From: Sue Howell <Sue.Howell@arun.gov.uk>
Sent: 26 January 2021 14:49
To: Planning.Responses <Planning.Responses@arun.gov.uk>
Cc: Simon Davis <Simon.Davis@arun.gov.uk>
Subject: RE: Planning Consultation on: Y/71/20/RES

Response to Planning Application

Application ref: Y/71/20/RES

Description: Approval of reserved matters following outline consent Y/88/18/OUT for the erection of 38 No. dwellings.

DD427L01-L02 Landscape General Arrangement Plan

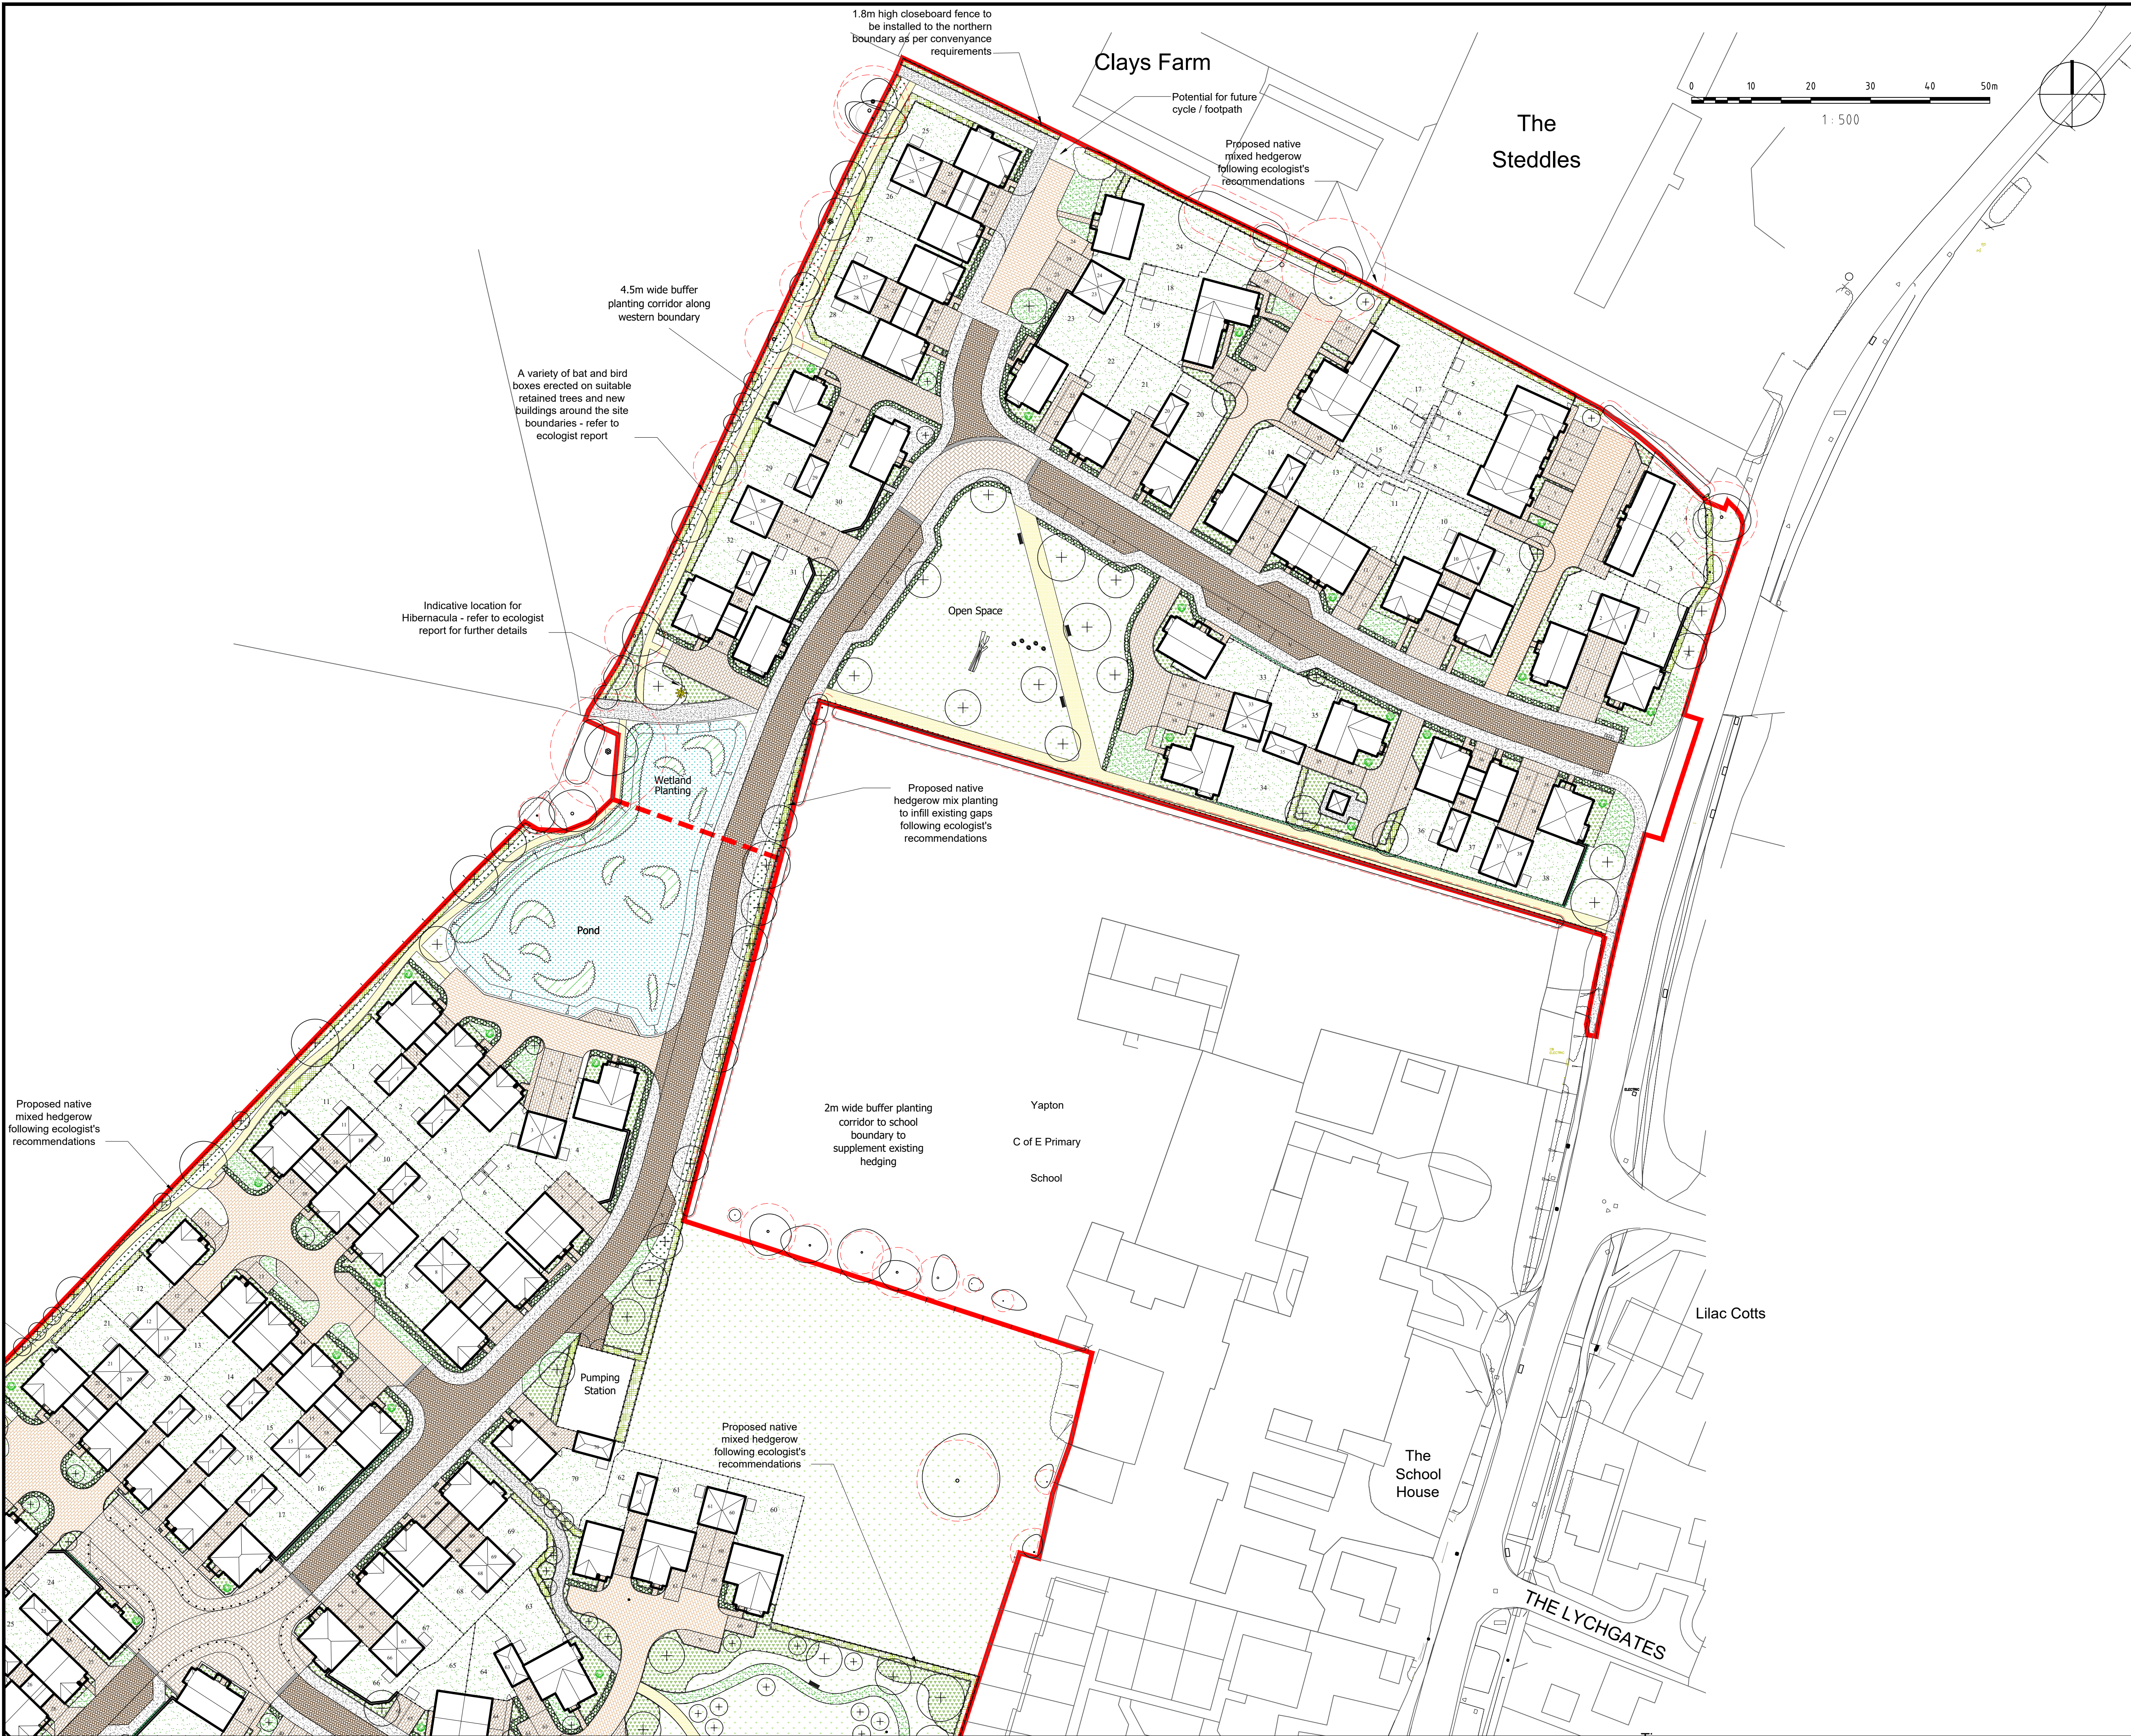
Further to receipt of amended plans and specifically in response to superseded drawing Landscape General Arrangement plan DD 427 L01 Rev B I can see no positive landscape change and my comments and recommendation as detailed in my consultation response of 08/10/20 remain valid.

- Clarification re the Parish requested DDA compliant footway and PRow within the site and its connectivity beyond the site. It is not clear if this pathway has been afforded the stated buffer zone? And how it links to the adjacent development of Clays Farm? The drawings at present do not show a joined up network of pathways and the north/east connection appears to run over a grassed area and to a detailed close board fence without connectivity through. It is also unclear of how the pathway adjoins North End Road. It is also stated in the drawings that the pathway through the POS are to be 'hoggin' pathways? This may not be classified as a suitable DDA compliant surfacing and attracts maintenance issued in highly trafficked areas. Tarmac pathways would be more suitable for this purpose.

- Layout – It is a shame that the dwellings that sit at the entrance to North End Road face side on, therefore giving a view of side fences at the entrance to this site from North End Road. Planting along this entrance has been setback to allow for sightlines however as an entrance the present layout could be much improved.

- The POS in this section appears to be an open green area which is satisfactory, in light of the LEAP offer being provided in the southern adjoining parcel of development. It does however indicate logs and seating, clarification be sought regarding the formality of this and if this is shown as a LAP?
